**KIRKLEES COUNCIL
TOWN AND COUNTRY PLANNING ACT 1990
HIGHWAYS DEVELOPMENT MANAGEMENT**

PLANNING REF 2018/62/92347/E0/WS
CATEGORY Minor

PROPOSAL PARTIAL DEMOLITION AND
CHANGE OF USE OF GROUND
FLOOR AND LOWER GROUND
FLOORS TO OFFICES AND
EXTERNAL ALTERATIONS(WITHIN
A CONSERVATION AREA)

LOCATION 92 NEW NORTH ROAD
EDGERTON
HD1 5QP

SCALE: 1:50 @ A1
DRAWING NO.: 0060/00-02
REVISION: -

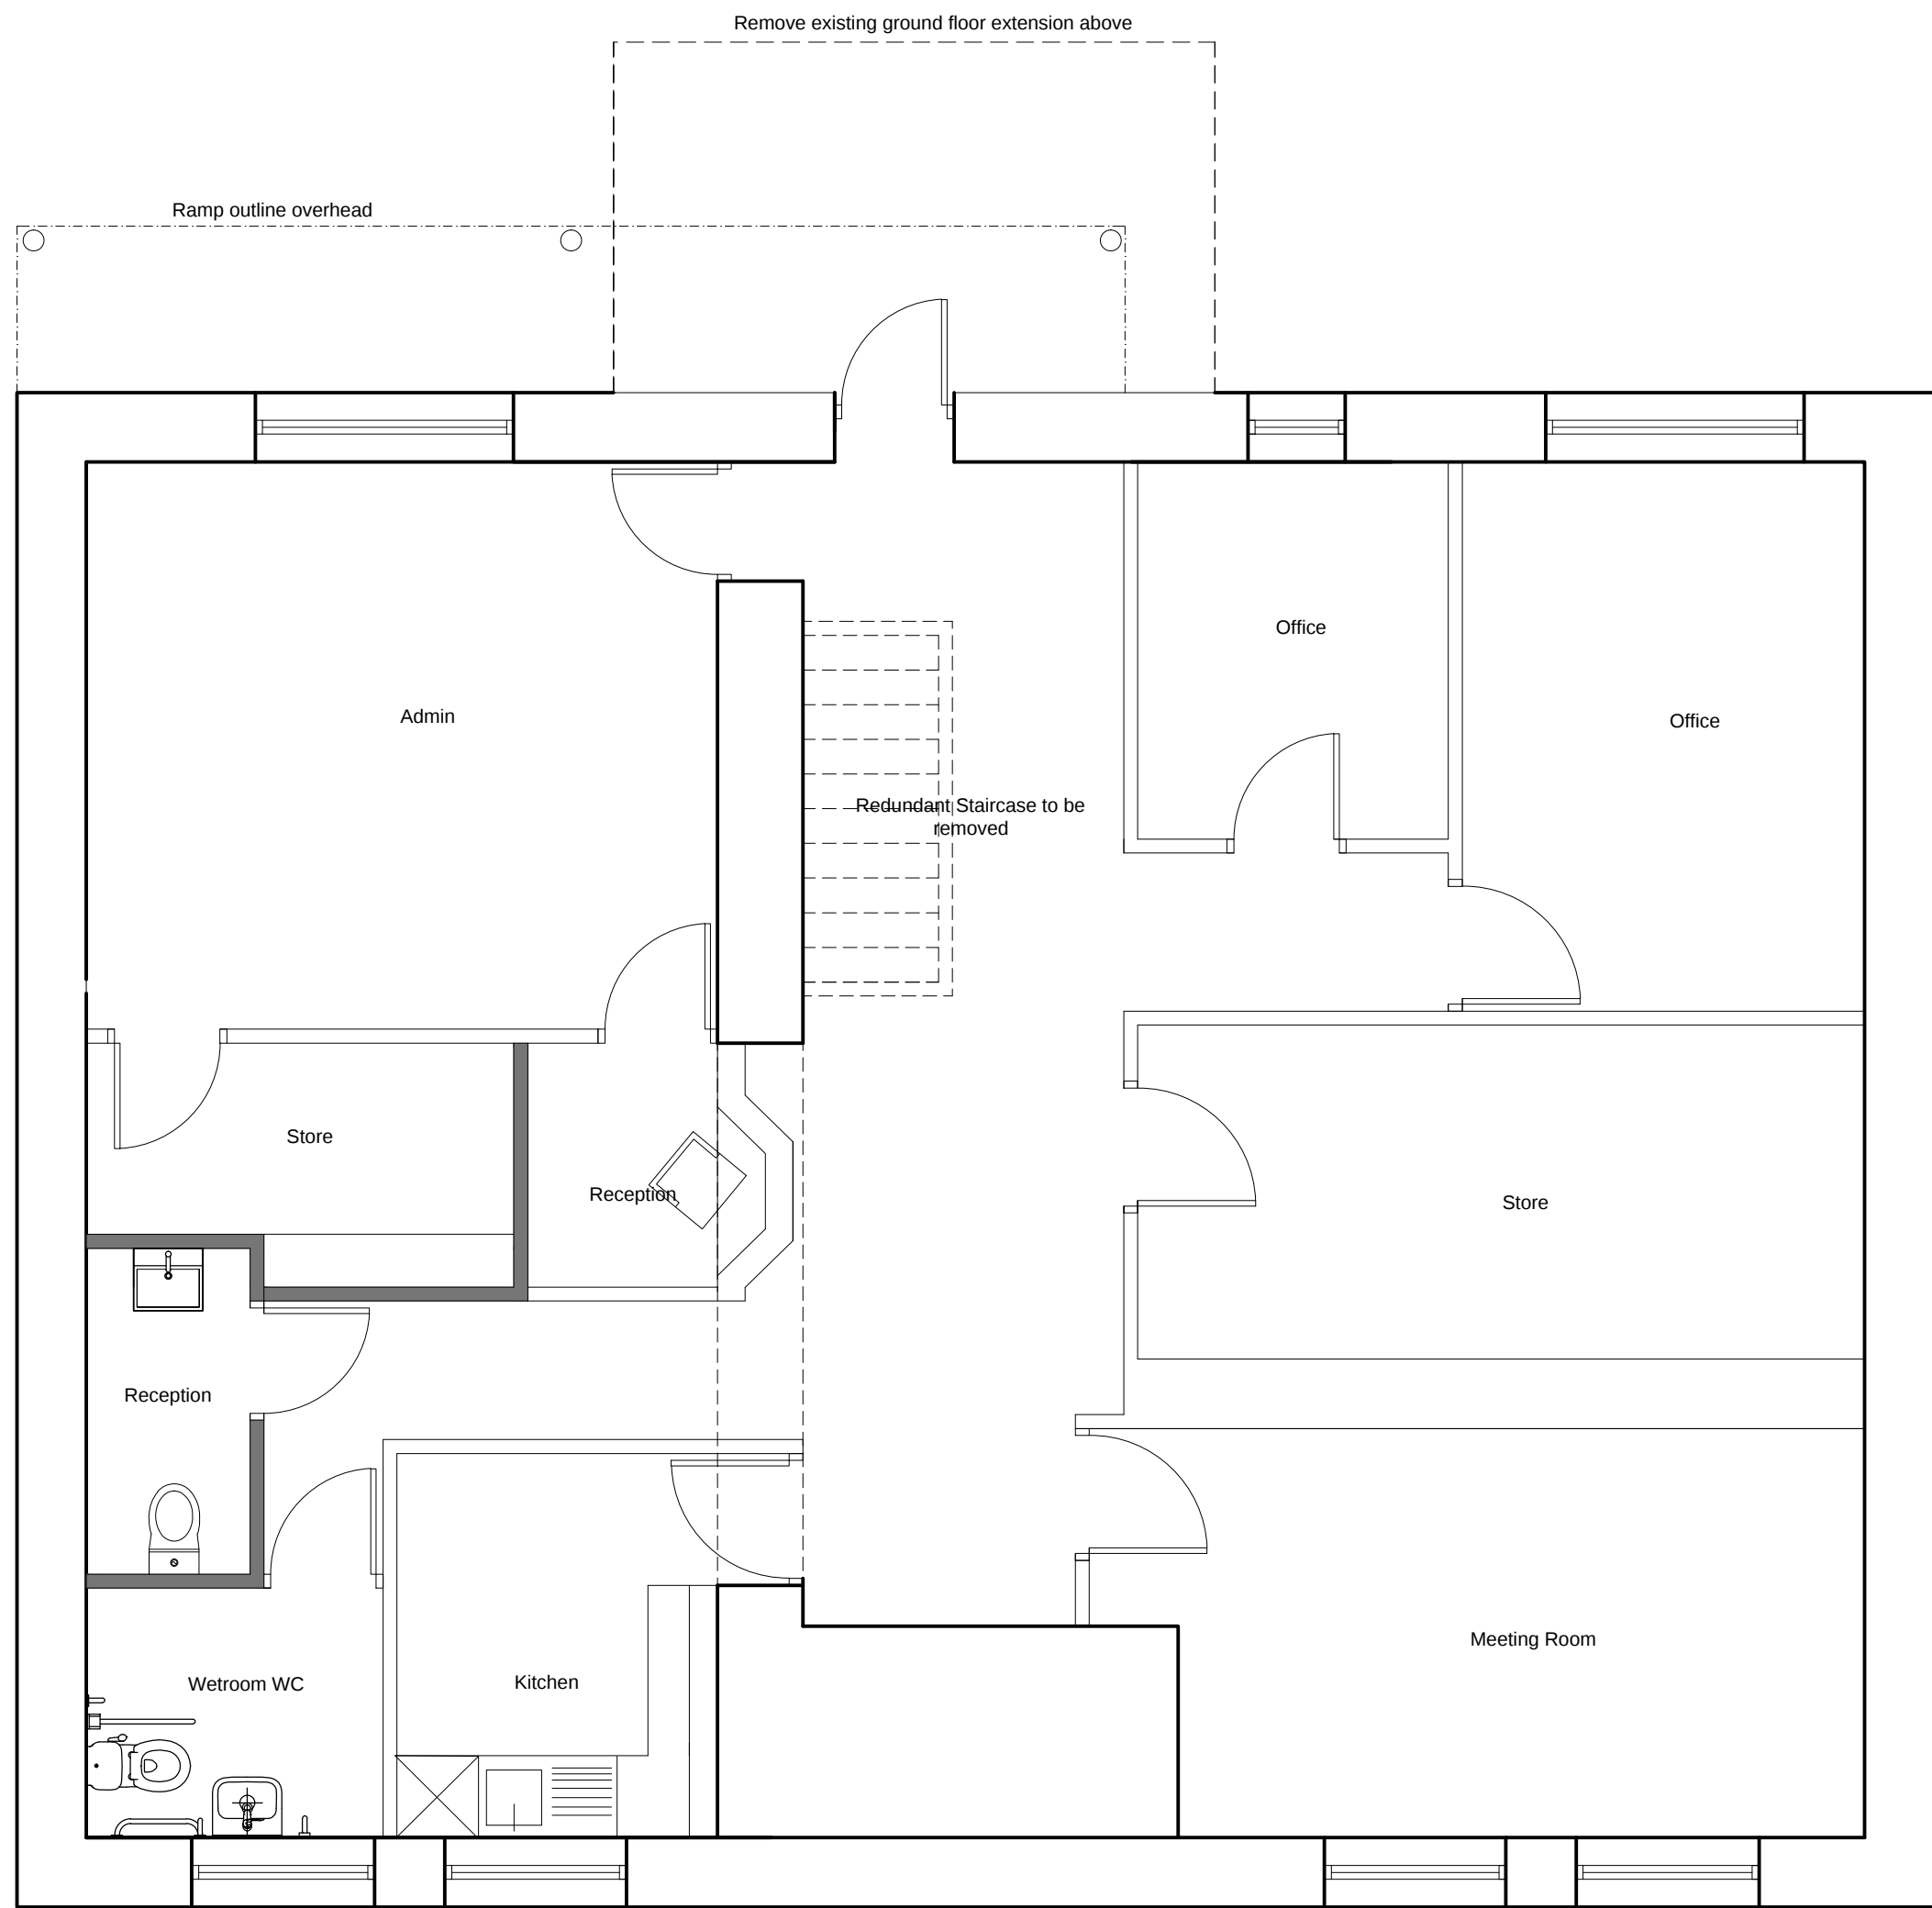
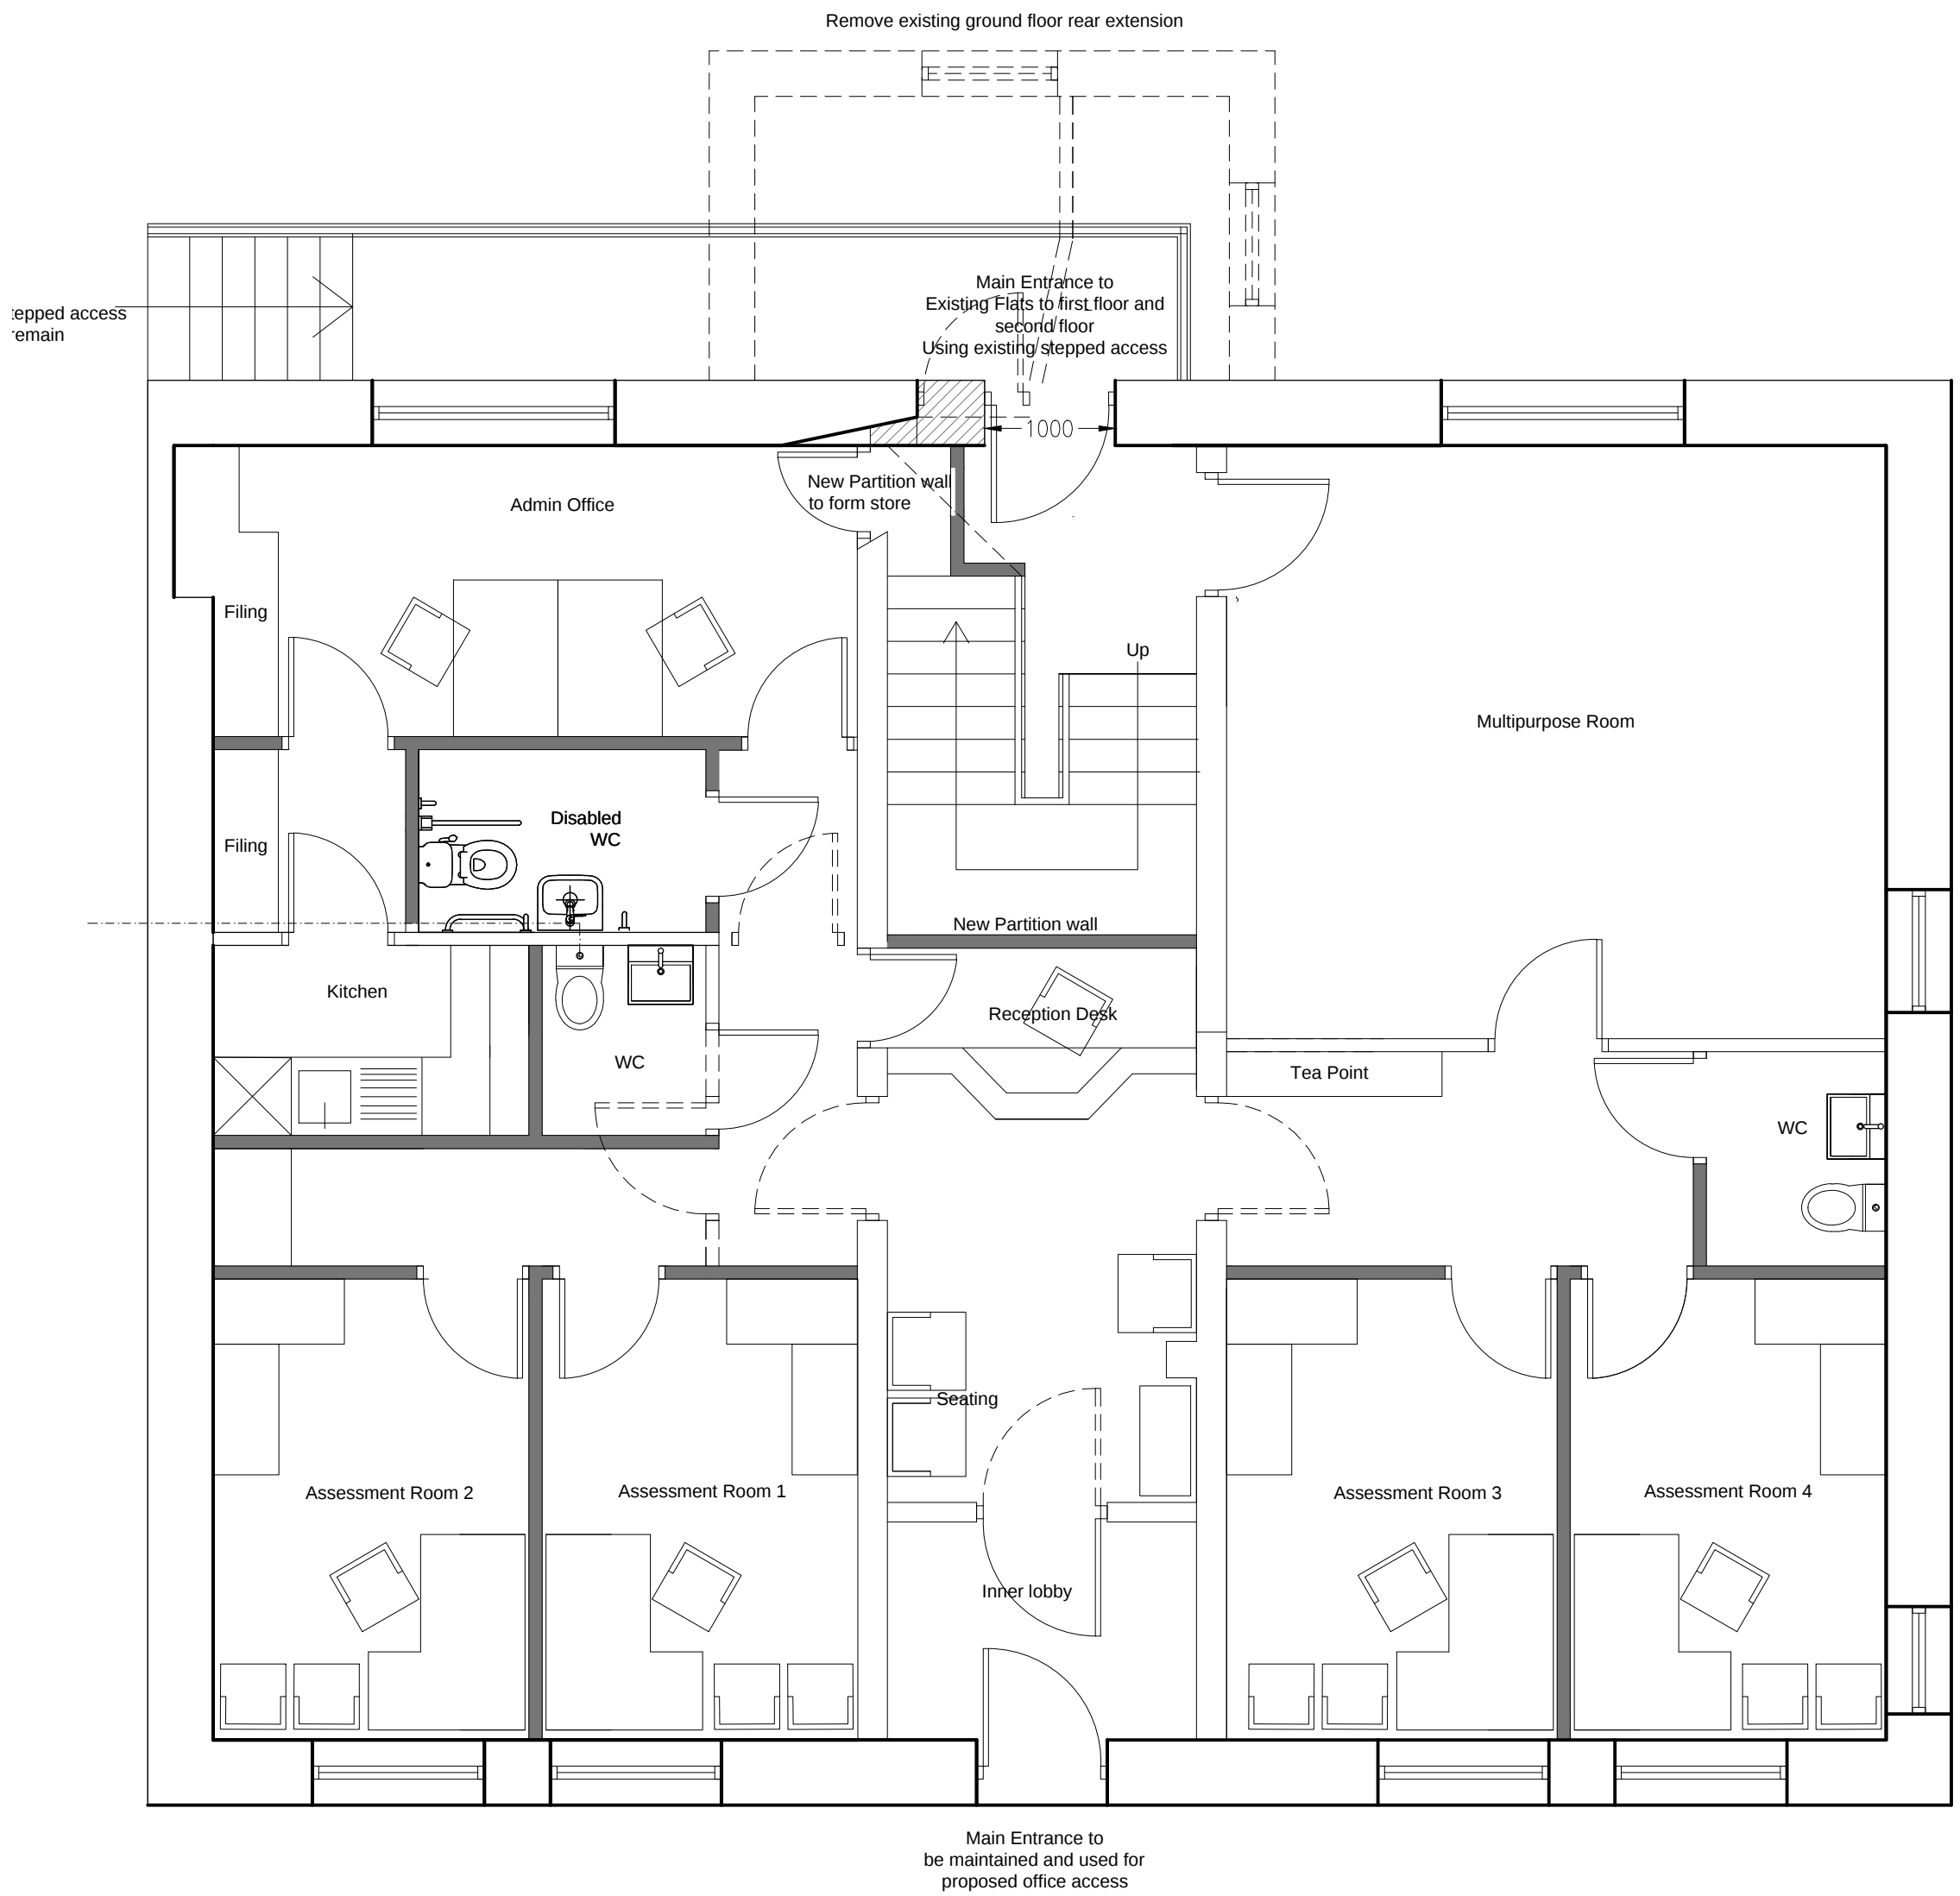
The development would retain three single-bedroomed flats on the top two floors, with the ground and lower ground floors converted from residential to office space. Access arrangements are to remain the same, being taken from a 4.4m-wide facility onto Cemetery Road. The current garages are to be removed to provide additional off-street parking spaces, with sixteen spaces being shown on drawing no. 0060/00-02.

On-site observations showed that cars do not currently park to the front of the site in the echelon manner shown, and the recommended distance of 6m between the bay and the house frontage to allow for turning cannot be achieved. It is likely that egress from these spaces will be extremely difficult, especially without using third-party land. A similar issue with manoeuvring space occurs at the parking to the rear.

No provision for the storage and collection of waste is demonstrated.

- Swept path analysis of a vehicle entering and exiting the site from the proposed parking bays (in particular spaces 10, 12, 5, and 6).
- Provision for the storage and collection of waste marked on a plan.
